Our ref: HA/2017/119859/02-L01
Your ref: LU/323/17/PL
Date: 16 January 2018

FURTHER INFORMATION - CHANGE OF USE OF FORMER UNITED SERVICES CLUB (SUI GENERIS) TO 10 NO. FLATS (C3 DWELLING HOUSE) WITH ASSOCIATED LANDSCAPING, PARKING, BINS & RECYCLING STORAGE.

UNITED SERVICES MALTRAVERS ROAD LITTLEHAMPTON BN17 5NA

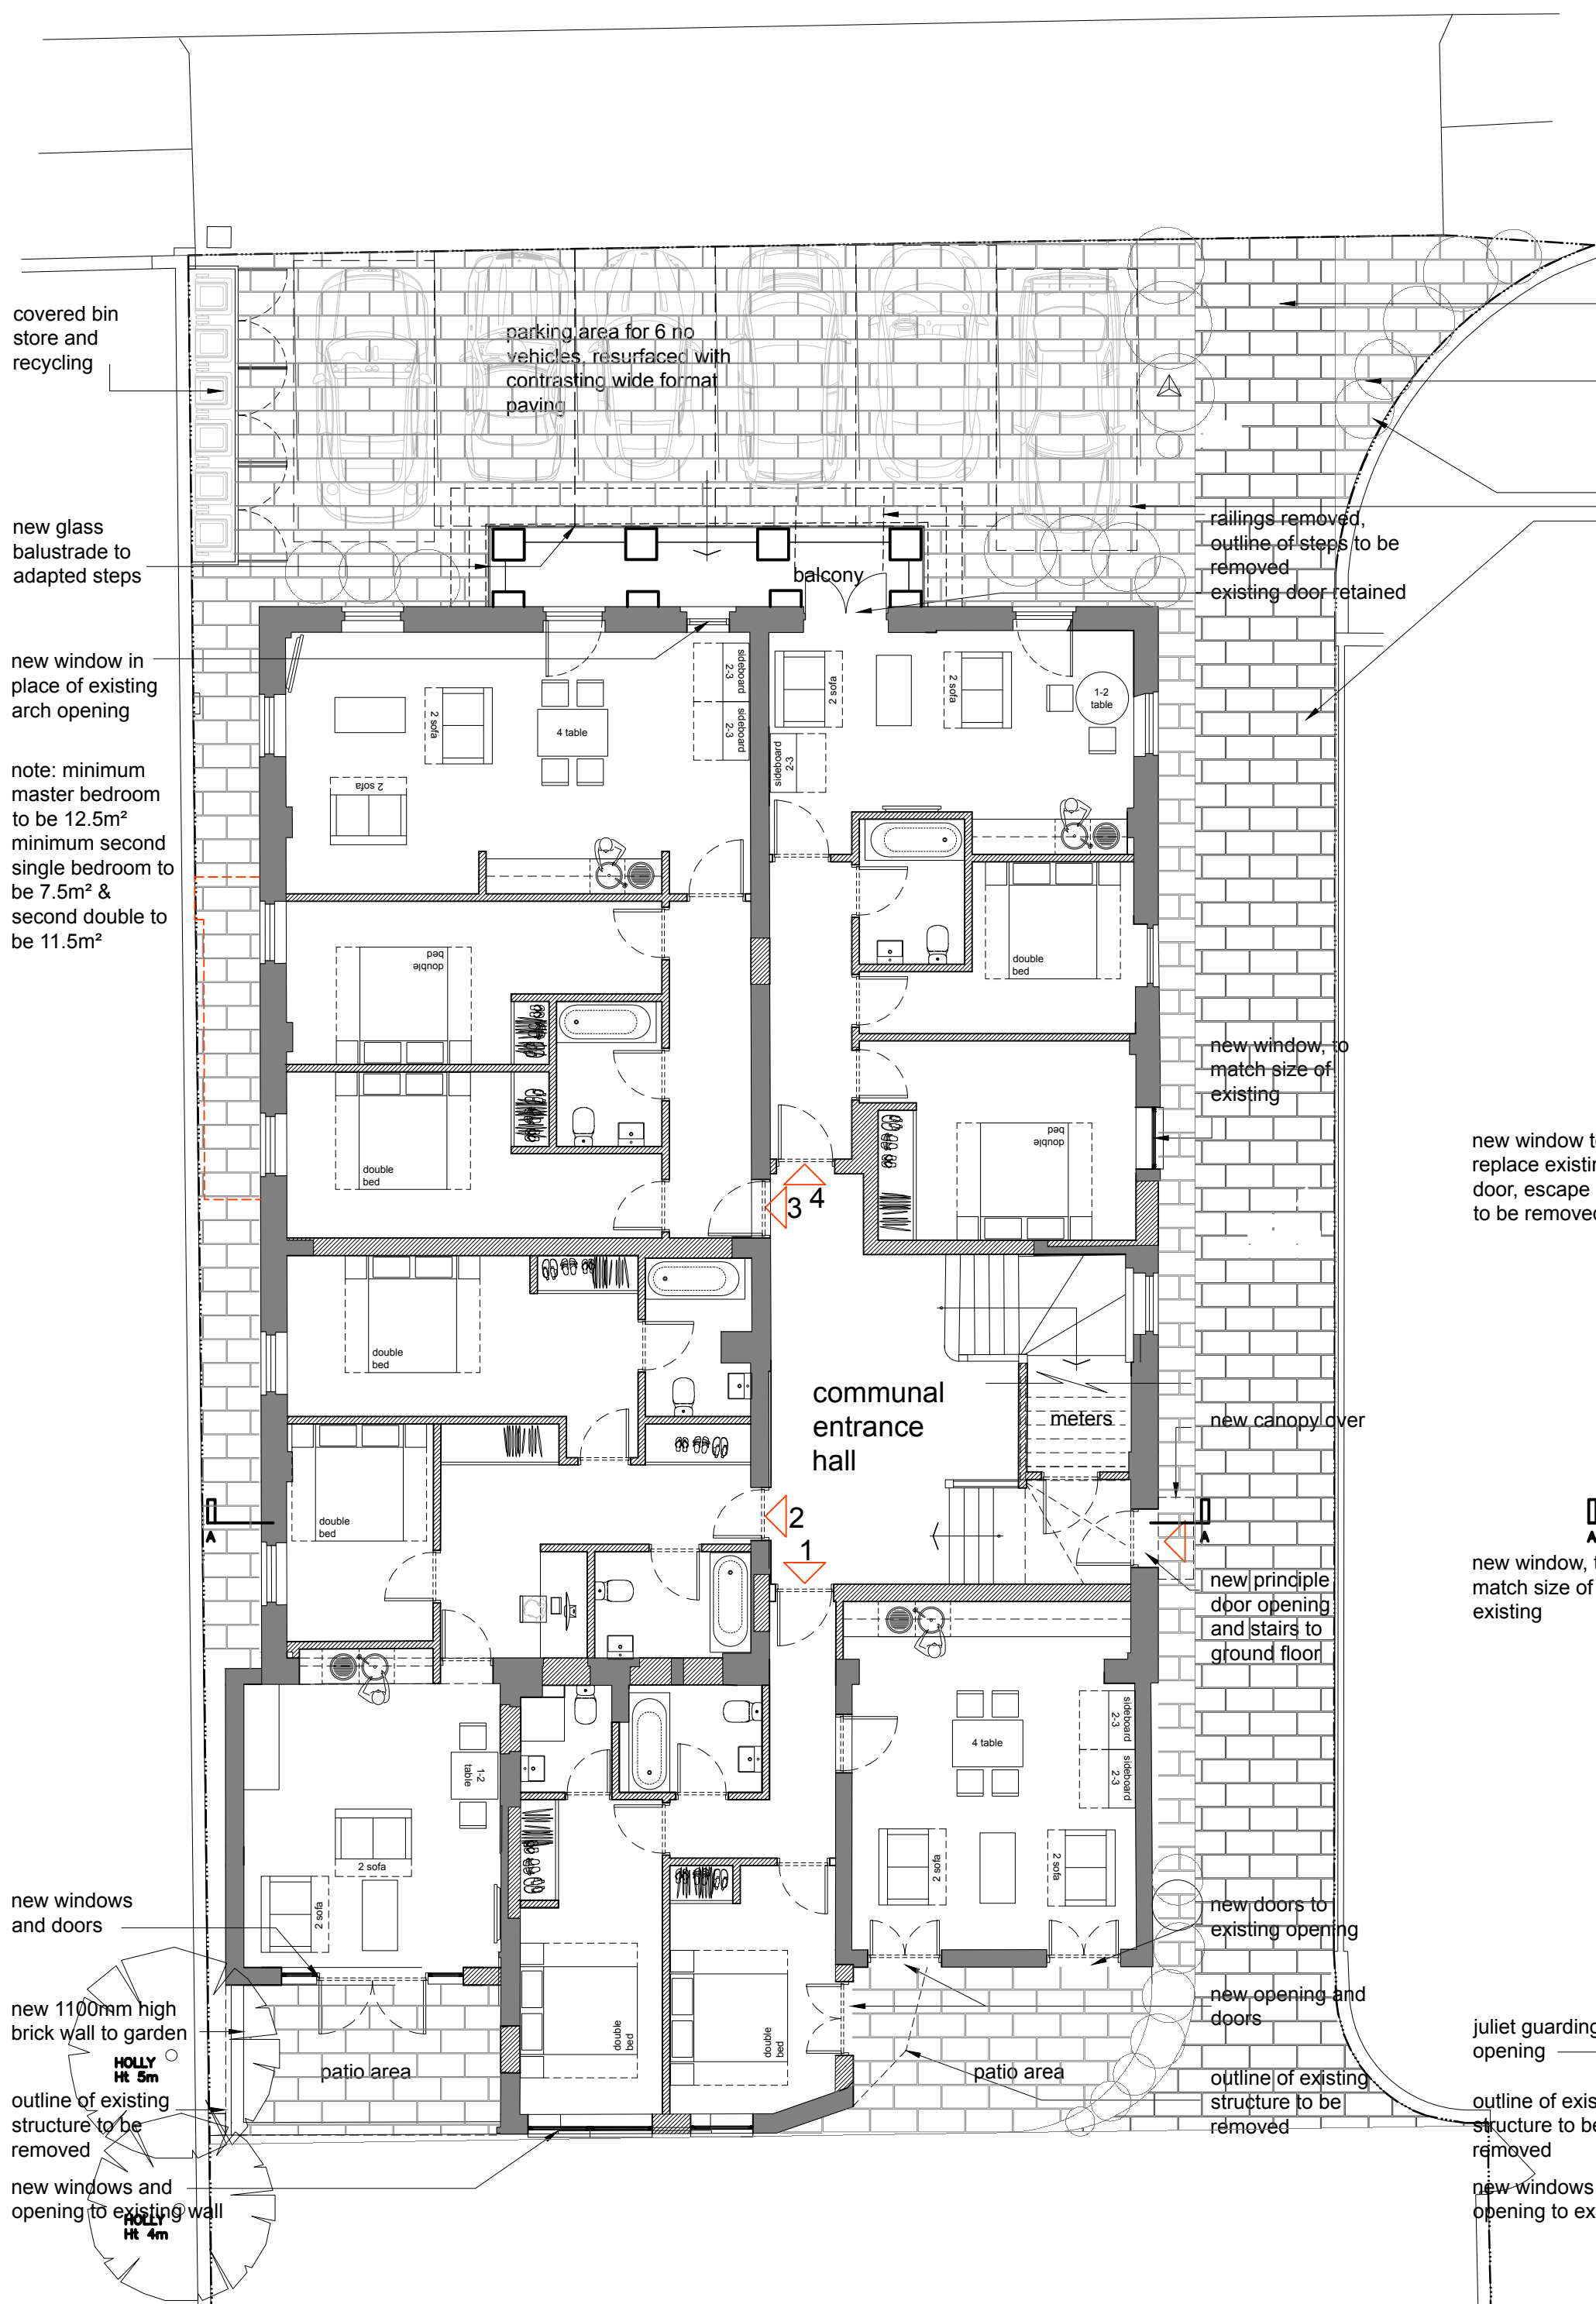
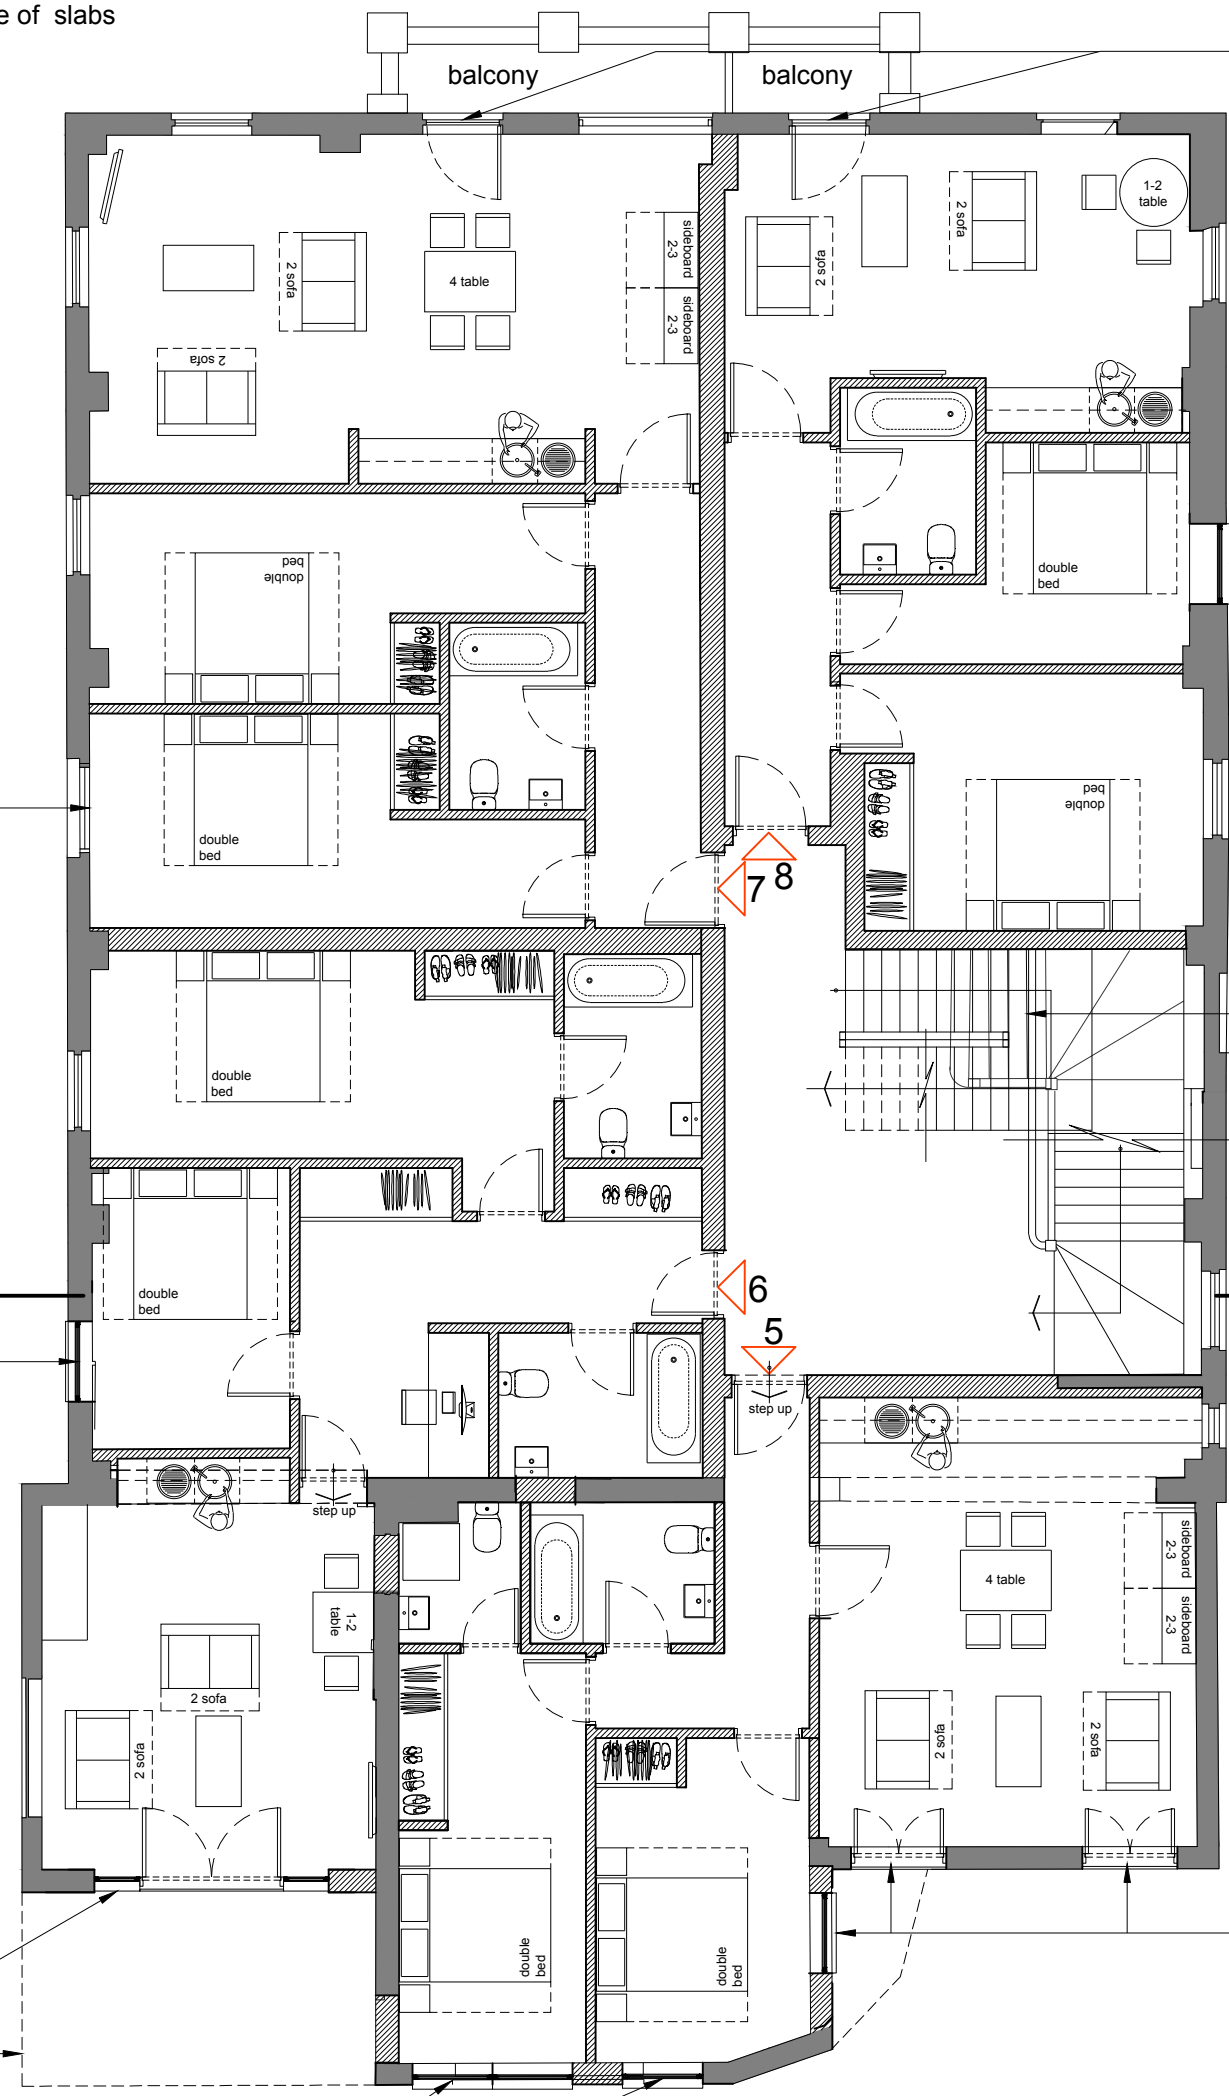
The proposed development will only meet the requirements of the National Planning Policy Framework if the following measure(s) as detailed in the Flood Risk Assessment (December 2017) and Proposed Building Plans (ref. 0041.PL.002A and 0041.PL.003B, September 2017) and submitted with this application are implemented and secured by way of a planning condition on any planning permission.

- **Finished floor levels are set no lower than 5.20 metres above Ordnance Datum (AOD).**
